Application No: EP/115/20/PL
Site Address: 4 Beechlands Close & land rear of 18 Montpelier Road East Preston BN16 1JZ
Description of works: Side extension, loft conversion & detached garage to existing dwelling & erection of 2 No semi detached houses. This site is in CIL Zone 4 & is CIL Liable as new dwellings.

Thank you for your internet representation made on 3rd November 2020 which has been recorded as an objection with the comments as follows:

FRONT ELEVATION EAST

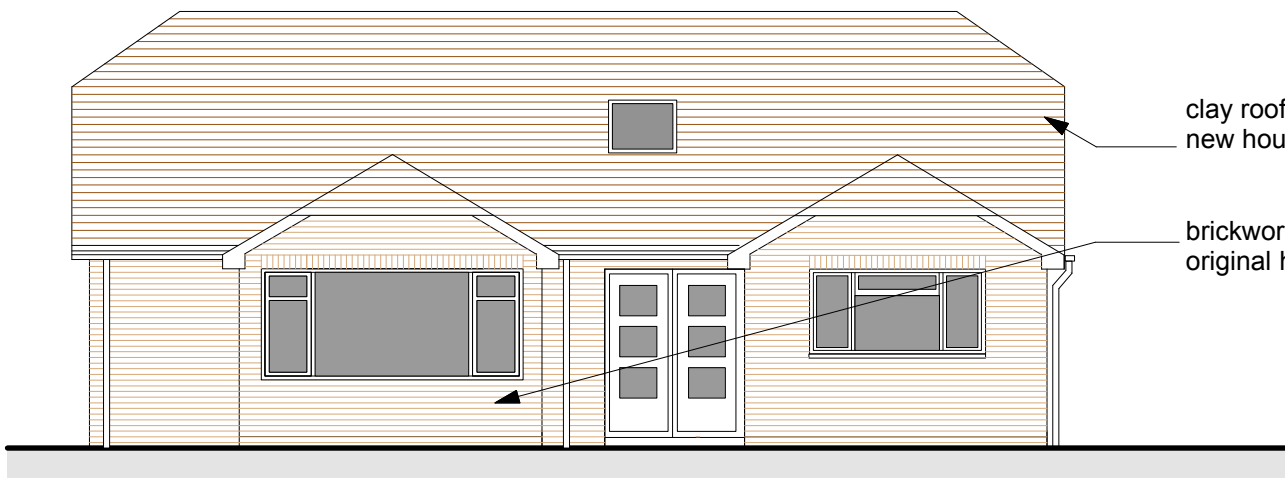
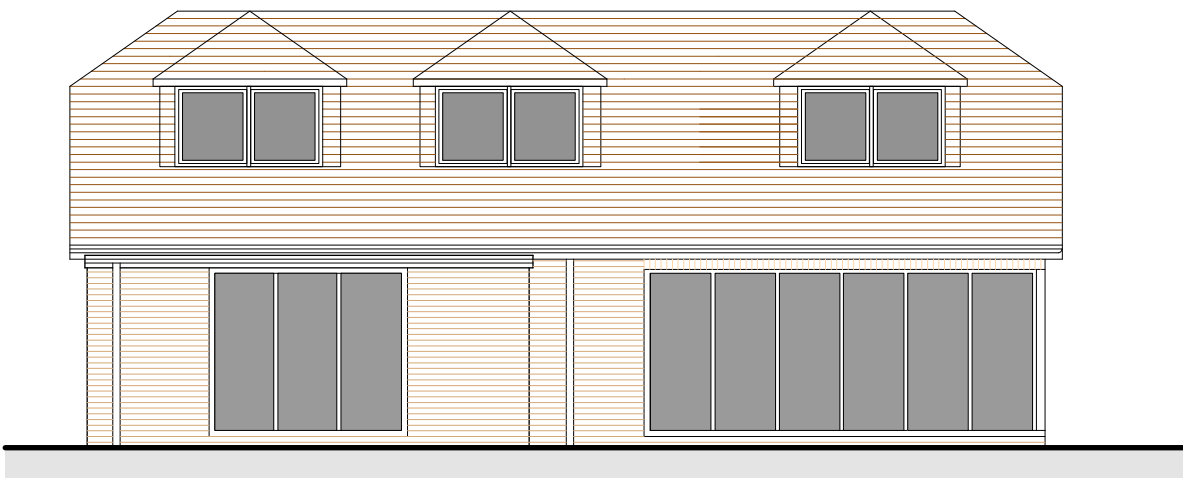
The existing height of the bungalow roof at no 4 requires a significant increase to accommodate an additional storey which will change the outlook substantially from our garden. We also note that although there are various designs to the properties in Beechlands Close they are in "groups" of identical or similar design and the properties in that section are all constructed with a similar height roof line

REAR ELEVATION WEST

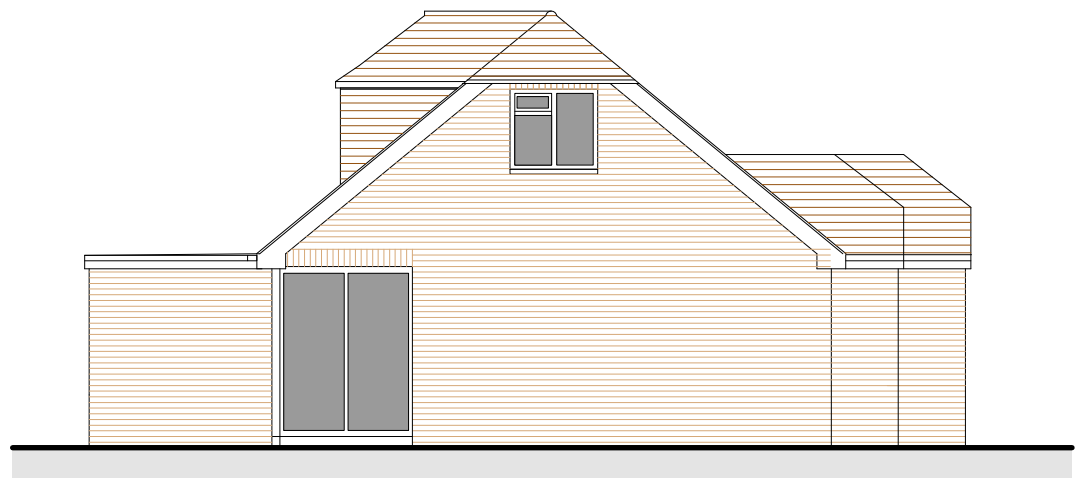
It is not exactly clear from the plans but it appears that the rear of the building currently defined by a conservatory will be extended out further and so closer to the back fence (which adjoins us) leaving a much smaller gap between the property and boundary. Added to this it is proposed to move the garage of no 4 forward and increase its size and this overdevelopment feels unwarranted.

The proposed design shows 3 x bedroom windows directly overlooking our garden which will impact on our

privacy particularly given the close proximity to our boundary and new proposed height of the property. If the proposed development was to be considered for approval, we would suggest and request a more appropriate approach would be to "swap" the upper floor design to have the dormers and windows on the eastern/front aspect with sky lights set into a sloped roof to the rear affording additional light but with less direct sight lines into our garden
